From:
Sent: 10 February 2026 15:27
To: DC Admin
Subject: Fwd: Re planning app 2023/93539 - Ledgard Wharf

Re planning app 2023/93539

Project	Proposed residential scheme at Ledgard Bridge, Mirfield	
Client	Binks Executive Homes Ltd, Cawthorne, Barnsley S75 4EJ	
Dwg Title	(17001)15_Walkway	A
Scale	1:200, 50, 20 @ A2	
Date	May 25

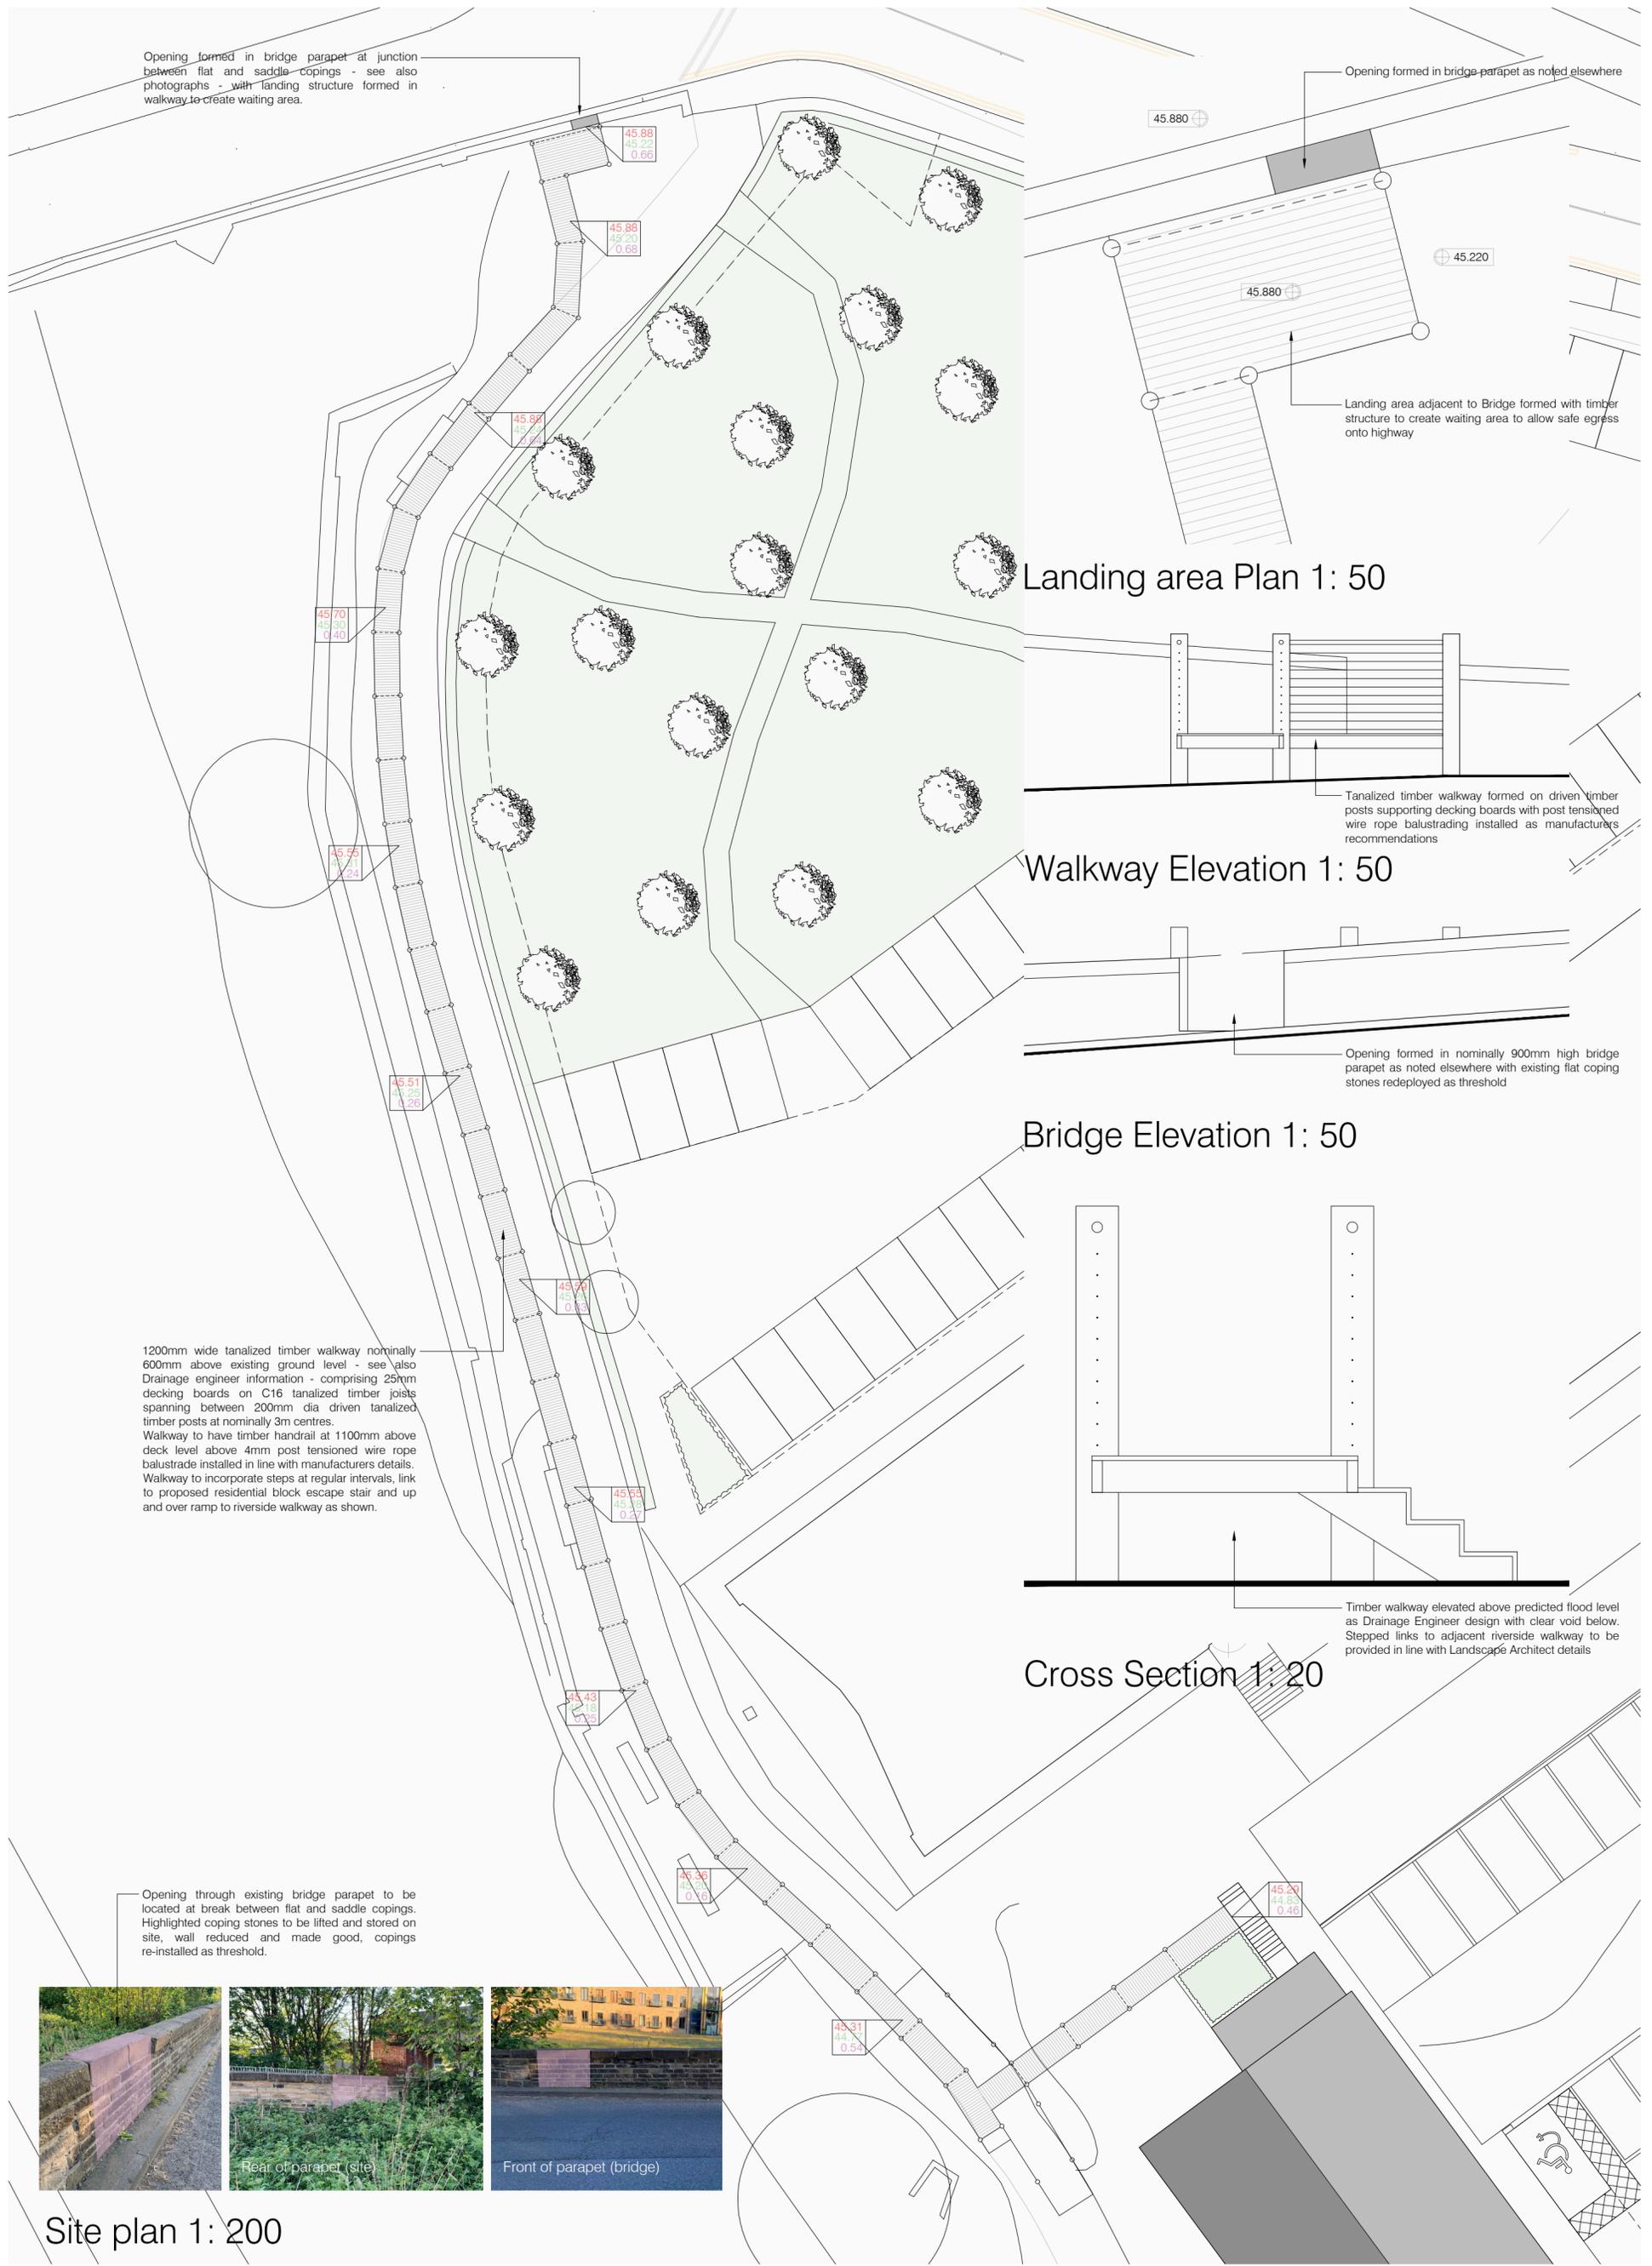
The recent additional plans and mitigations from the developer do not fully address the safety and flooding issues of the site. The proposed raised walkway doesn't enable safe movement and evacuation in the event of the next flood.

The walking route via the proposed walkway appears to be 110m long and would only be accessible for those people well and able enough to use it, and of course not to emergency vehicles.

How would less able people evacuate the building/development area or access help? How would people with mobility issues, heavily pregnant people, disabled people, the elderly, safely use this raised walkway?

The proposal includes various stepped access, with the physical route to dry land concluding with *"sit on parapet and swing legs over wall"* - this shows so little respect for residents as a suggested safe route for everyone in the event of an emergency, that I am astounded it has been put forward as the approach.

The following notes included on the latest plan indicate no regard for residents with protected characteristics:

"Step on platform to allow evacuees to sit on parapet and swing legs over wall to effect escape"

“Step on platform to read of parapet Shaun dashed to allow evacuees to escape onto bridge”

“Timber walkway... Stepped links to adjacent Riverside walkway to be provided”

“Platform to rear of bridge parapet to be provided with step to allow evacuees to sit on wall upstand and swing legs over to effect escape”
